Date 5 February 2024
Our Ref 24/00096/FUL

Town and Country Planning Act 1990 (As Amended)
48 Rosebank, Epsom, Surrey
Formation of new dropped kerb with vehicular access incorporating new hardstanding driveway.

Drawing Title
car park and drive

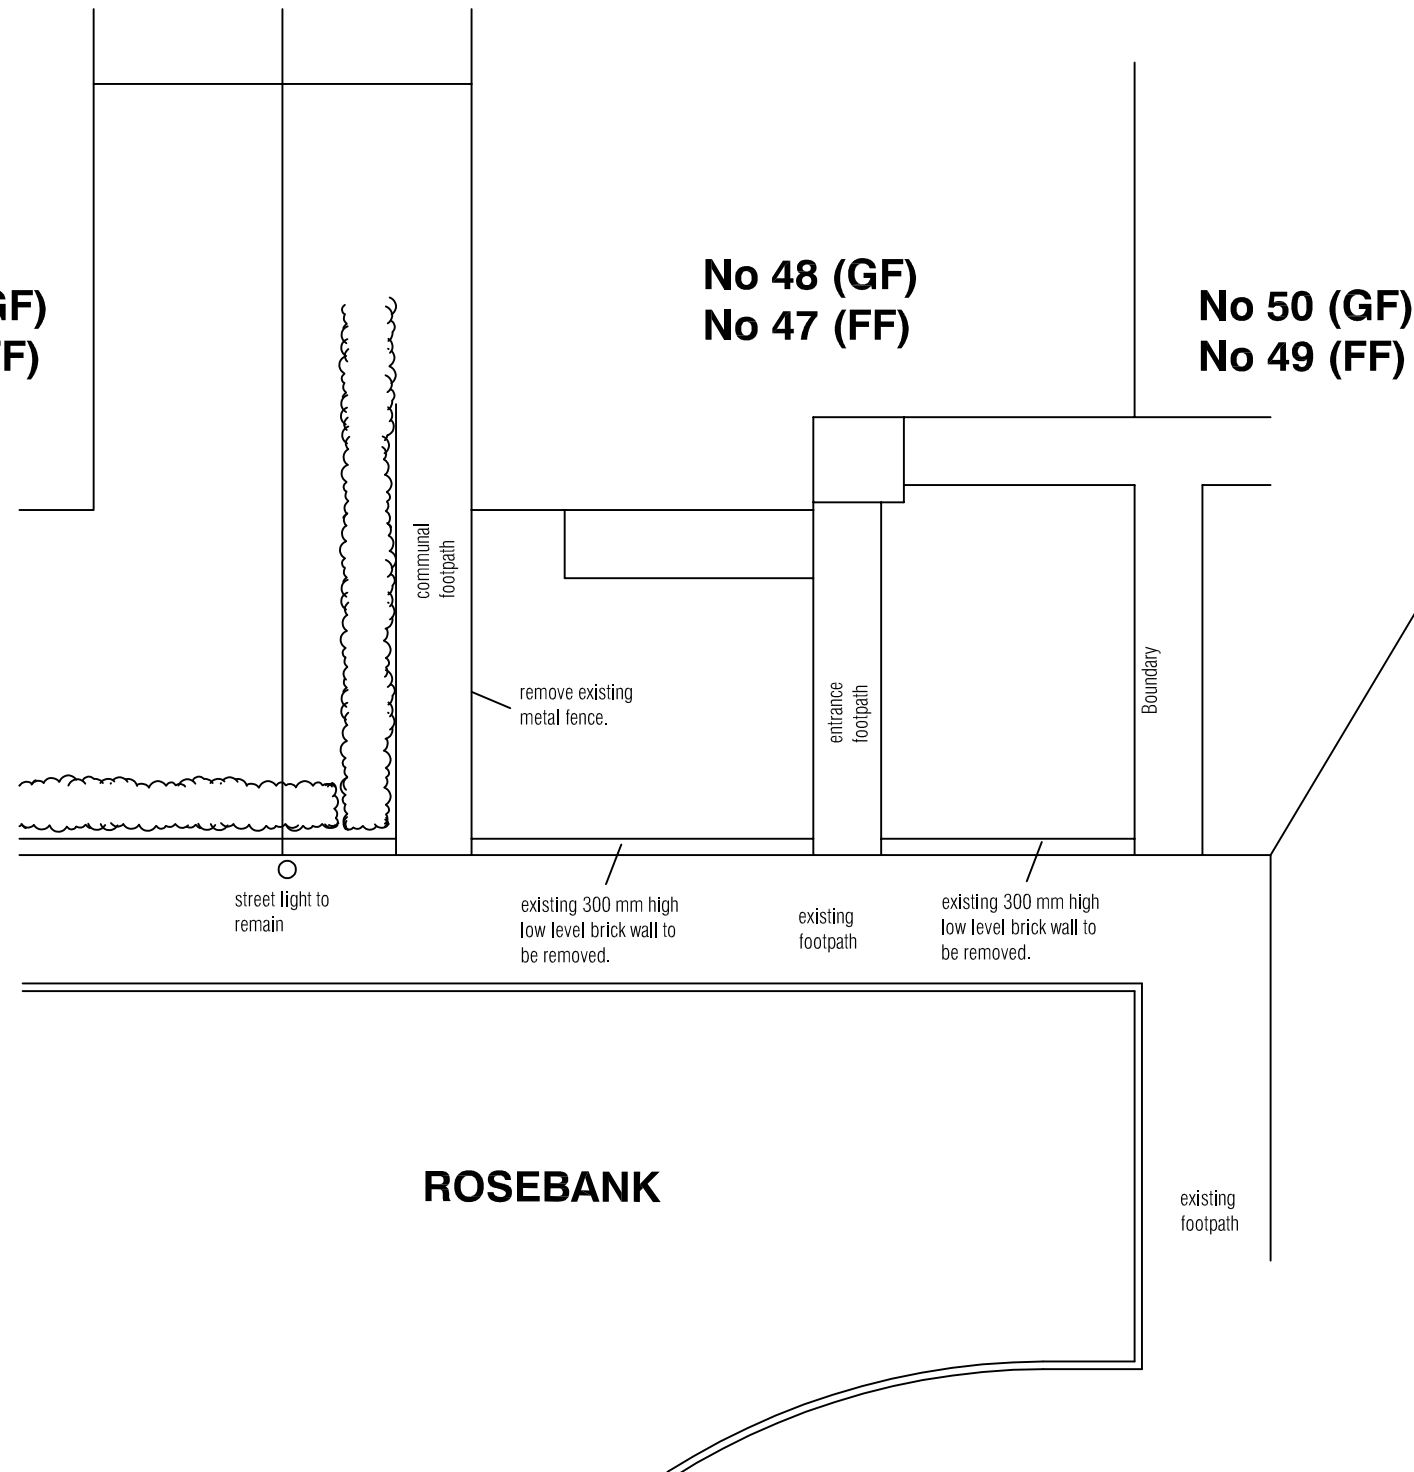
3 EXISTING AND PROPOSED SITE PLAN - Please submit an existing and a proposed Site Plan at a scale of 1:200 or 1:500 showing the proposal clearly differentiating from the existing (e.g. hatched) and its relation to the site boundaries, any other existing buildings on site and the neighbouring properties. The existing site plan is to show the current situation and the proposed plan is to show the proposed situation. As with the Location Plan, please ensure the plans incorporate the pavement and the dropped kerb.
